**RE: Harnett County Land Use Application HTE#06-5-16301RR**

On September 20, 2007 an attempt was made to evaluate your property for the purpose of issuing an Improvement Permit. The evaluation could not be completed for one or more of the following reasons.

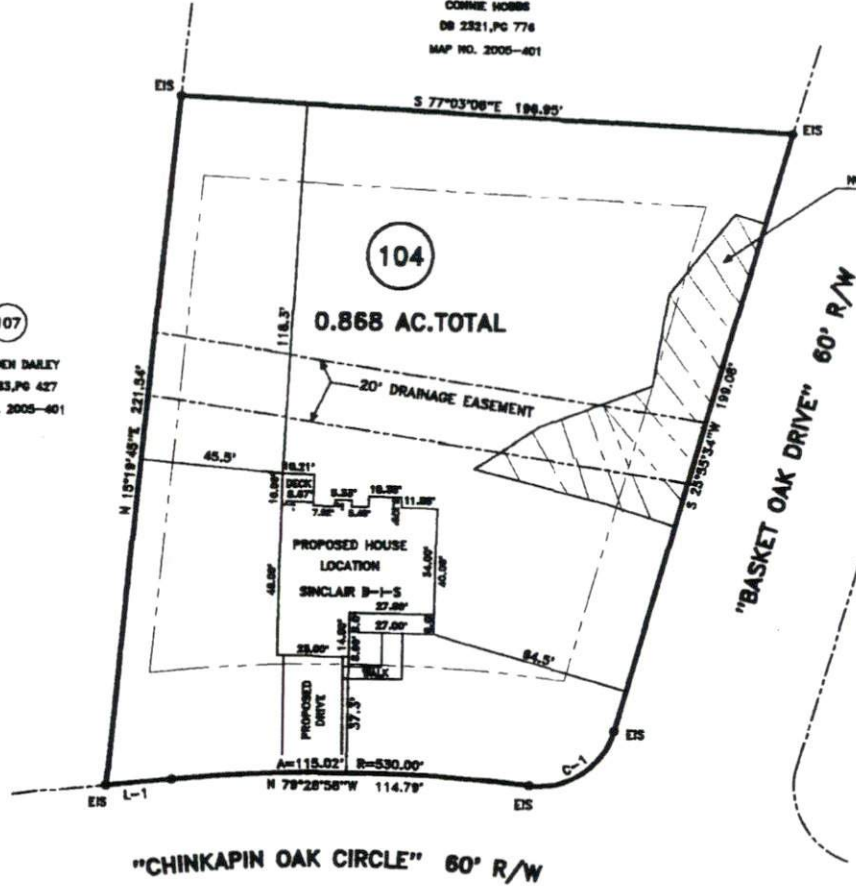
- 1. Property lines/corners not marked or labeled
- 2. House corners not marked or labeled
- 3. Directions not clear to property
- 4. Property needs brush or vegetation removed
- 5. Backhoe pits required
- 6. Other *Separated, lots 104 & 105 had septic easements for repair. Please submit map showing those easements & mark easement again on the ground.*
